PLANNING AMENDMENT

APPLICANT NAME AND ADDRESS MR M HASEEB SOVEREIGN PROPERTIES (ENGLAND) LTD 8 BLENHEIM COURT PEPPERCORN CLOSE PETERBOROUGH PE1 2DU Telephone:	AGENT NAME AND ADDRESS GOOD-DESIGN-ING LTD 11 SARACEN WAY NEWARK ROAD PETERBOROUGH PE1 5WS Telephone: 01733 569731
SITE ADDRESS DETAILS THE ROYAL BRITISH LEGION, CHAPEL STREET, CROWLAND, SPALDING PE6 0AR	
CURRENT APPLICATION NO: This amendment cannot be considered unless the relevant reference is stated.	H02-1272-21
Building Regulation reference relating to same development (if applicable)	N/A

DRAWING
Proposed First Floor Plan
Scale 1:50 @ A1 size
drawing number
211276-07 REV A

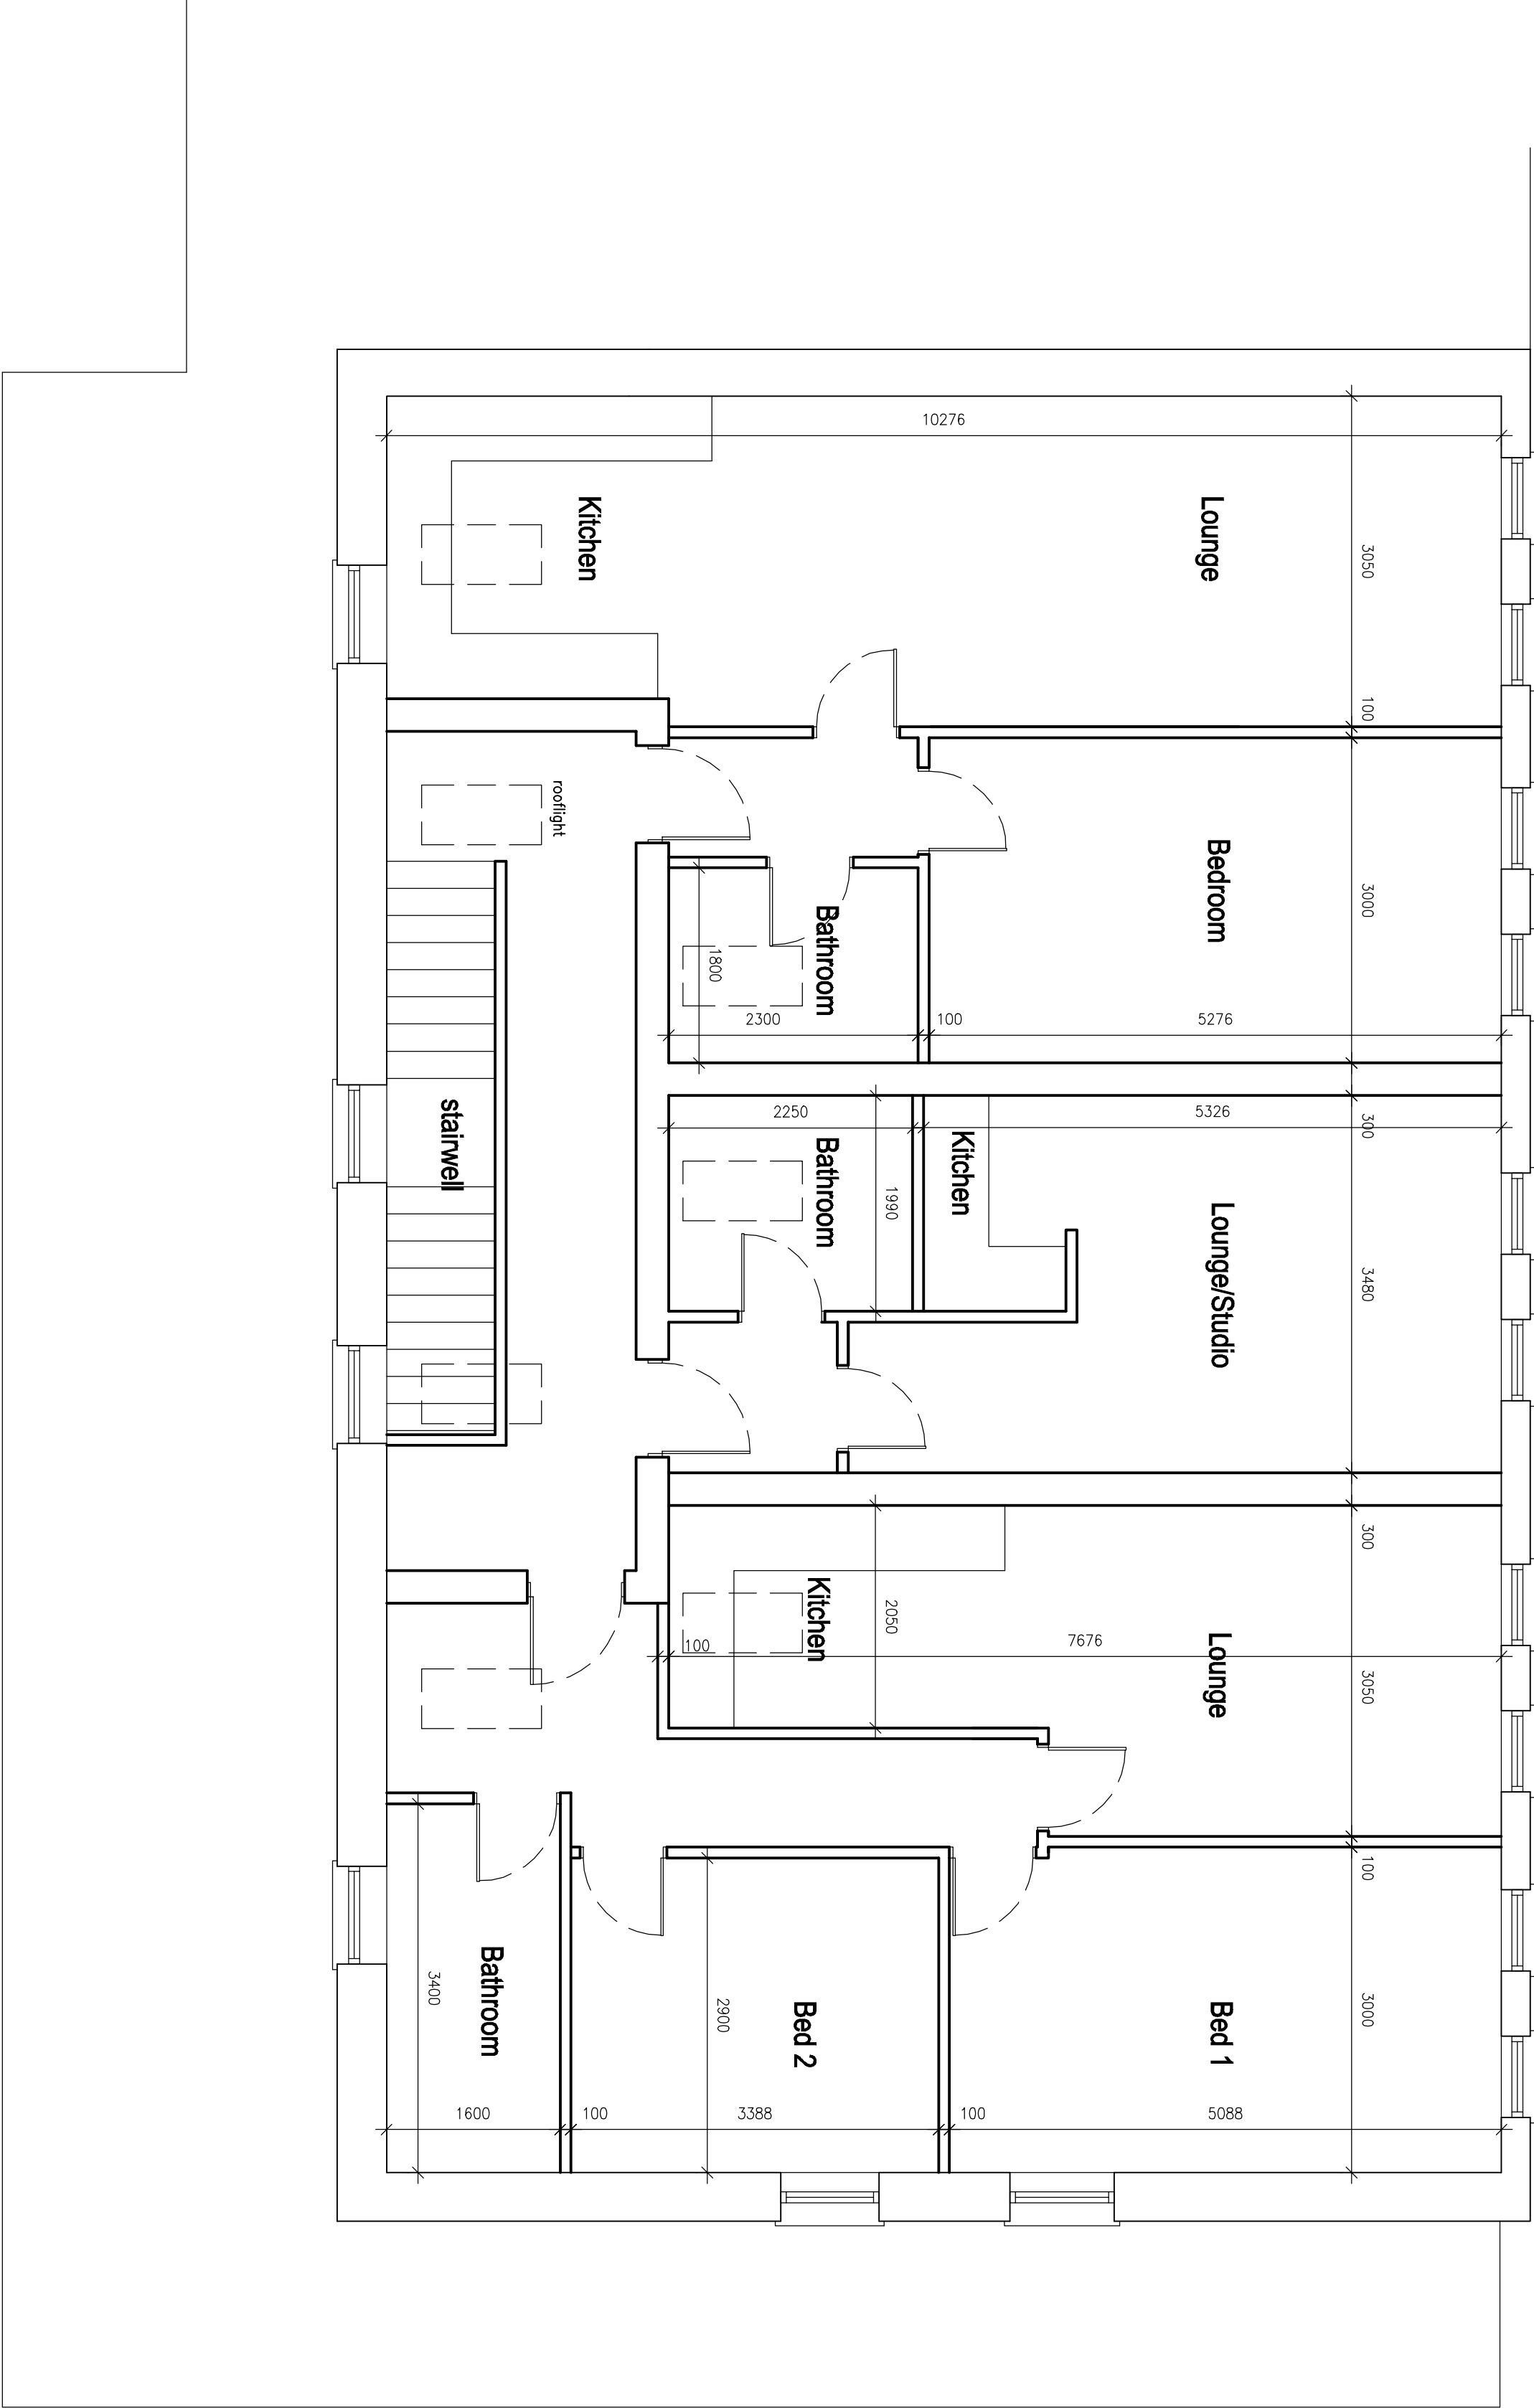
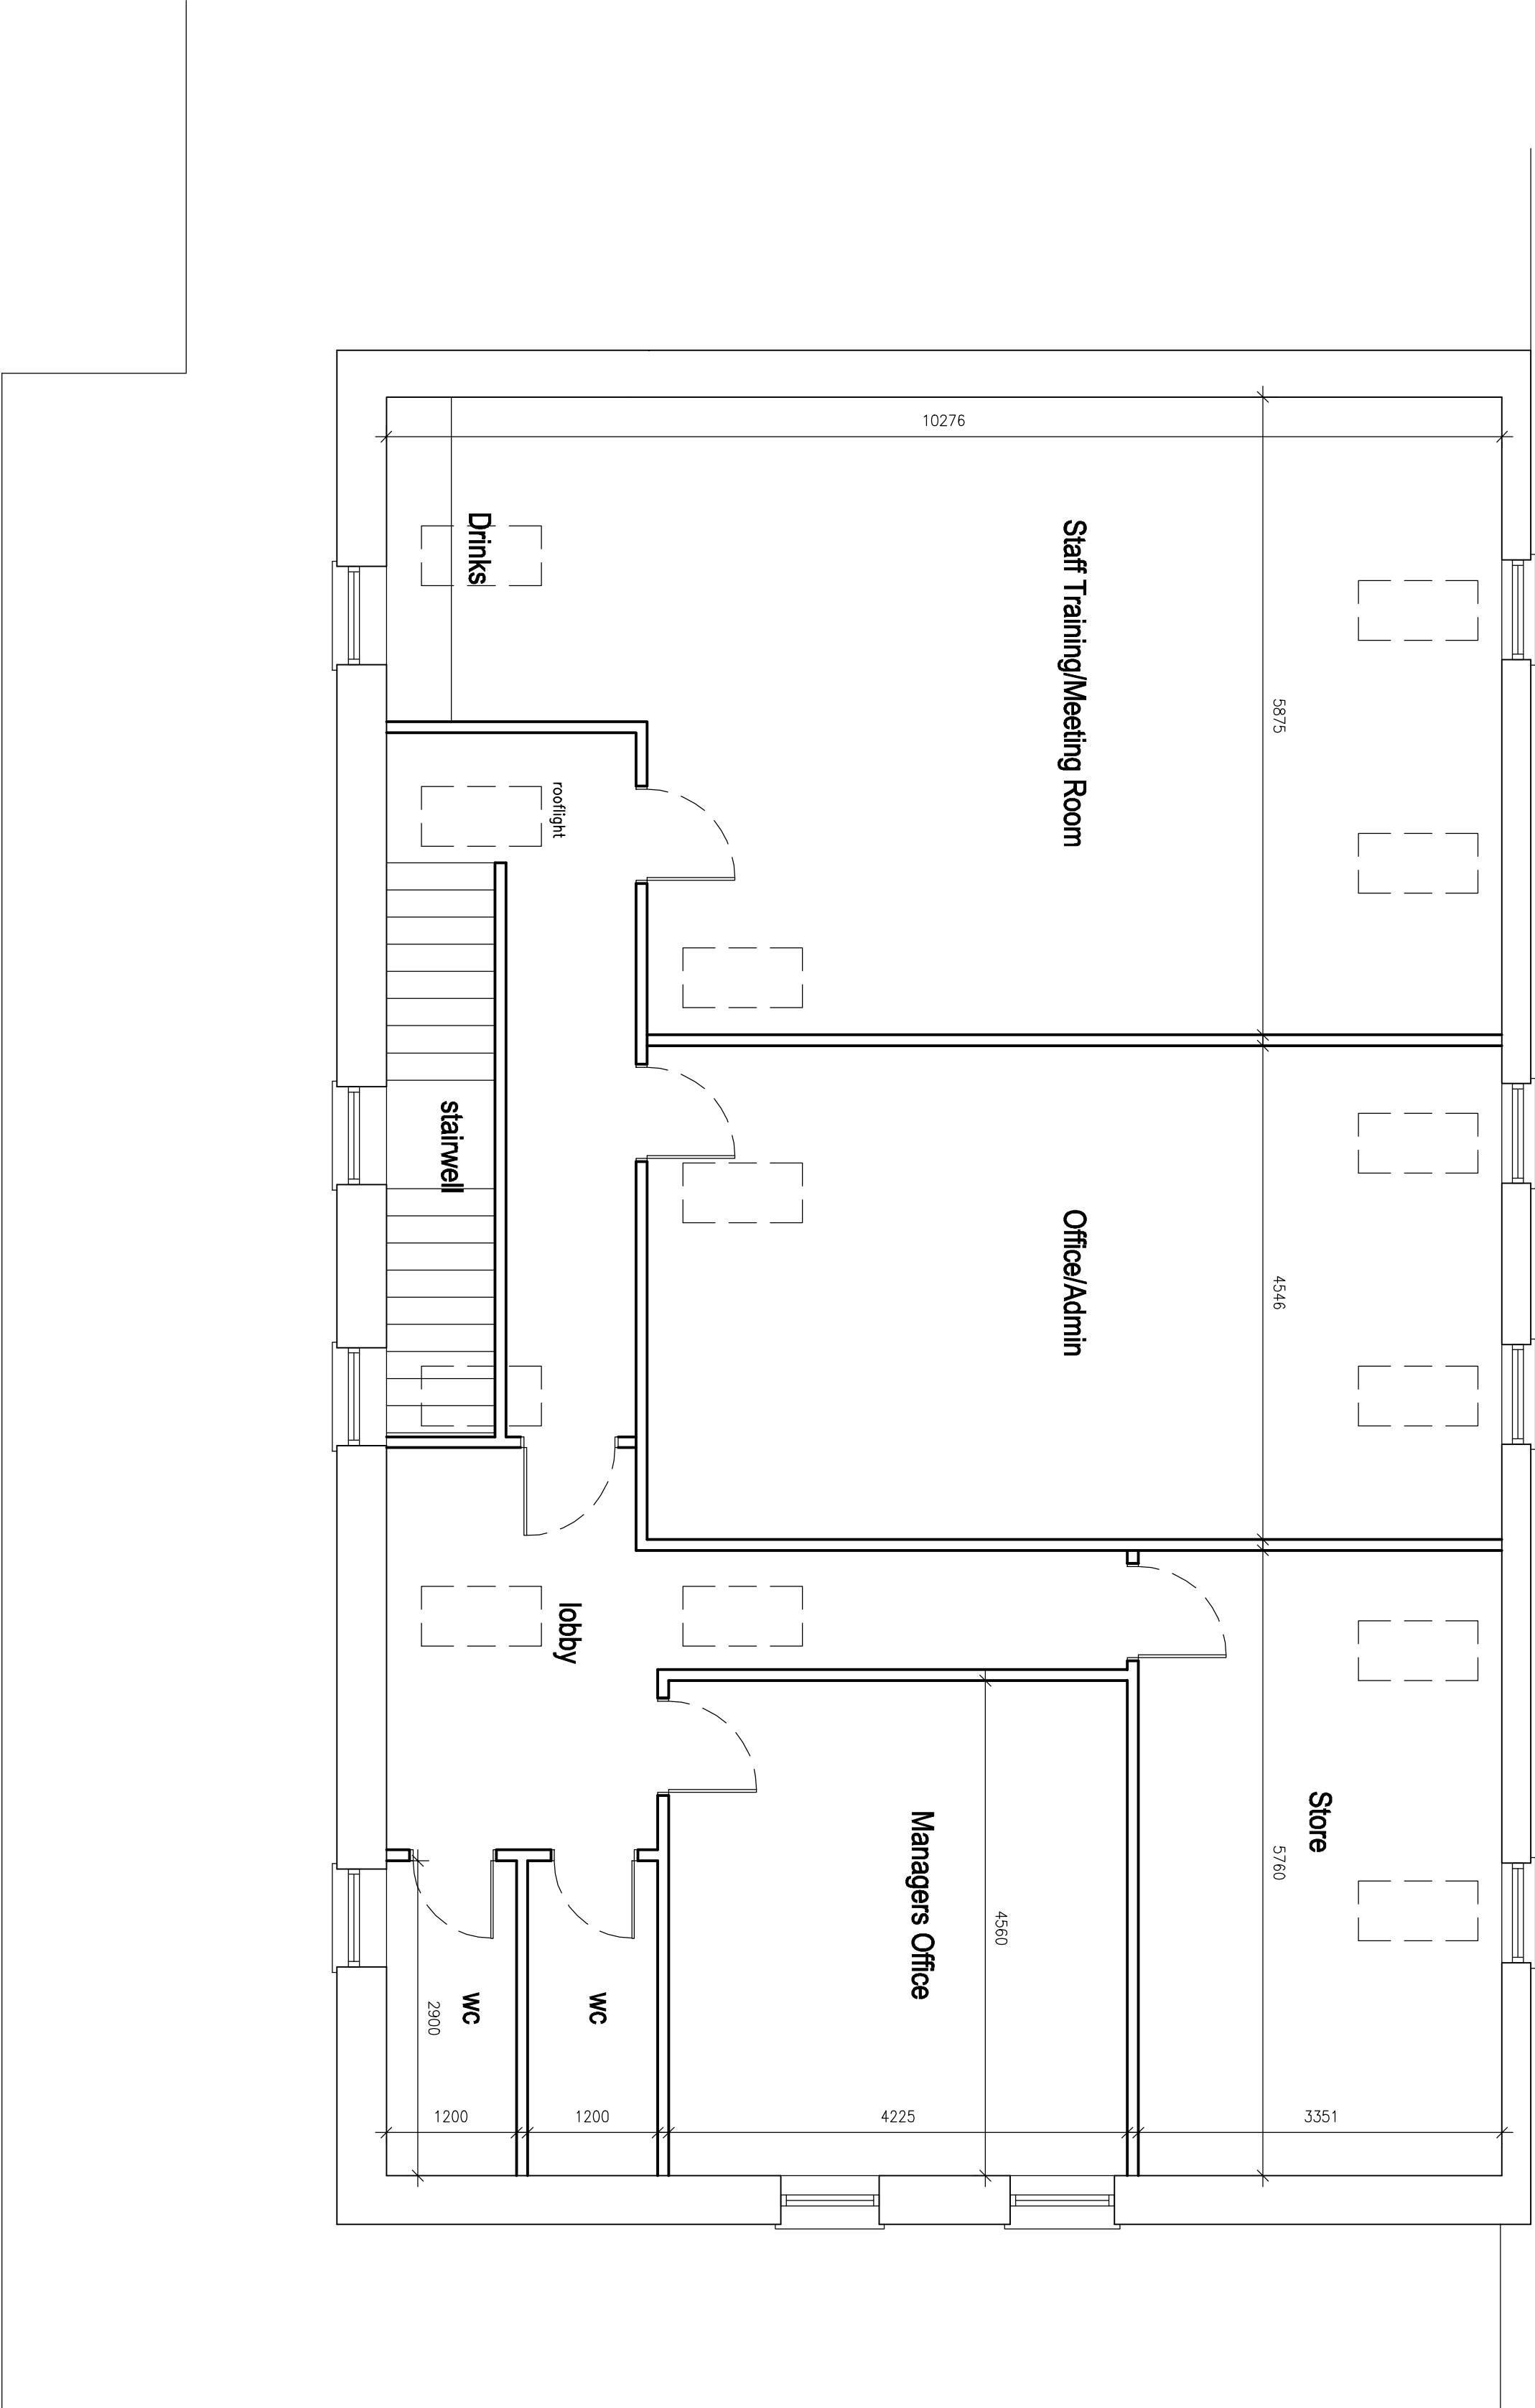
FULL DESCRIPTION OF DEVELOPMENT OF CURRENT APPLICATION THAT THIS AMENDMENT RELATES TO		
State details of amendments proposed. (Give a full detailed list of the changes; and also mark these clearly on the accompanying plans. Only the changes listed here will be considered)	CHANGES TO FIRST FLOOR AMENDED, EXTERNAL WINDOWS REMOVED, ROOFLIGHTS ADDED. TO NEW DRAWINGS 211276-04REV A, -05REV A, -07REV A -09REV A	
State drawing numbers of the current submission	211276-01, -02, 03, -04, -05, -06, -07, -08, -09	
Has this amendment been requested by the Council? (If so, state Officer dealing with the application)	YES/NO	NO
Describe any part of the original development which is excluded by virtue of the amendment, and state any alteration to plot numbers	CHANGES TO FIRST FLOOR USE, EXTERNAL WINDOWS REMOVED, ROOFLIGHTS ADDED	
Has a similar amendment been submitted under Building Regulations? (If so, state Building Control Surveyor dealing with application)	YES/NO	NO
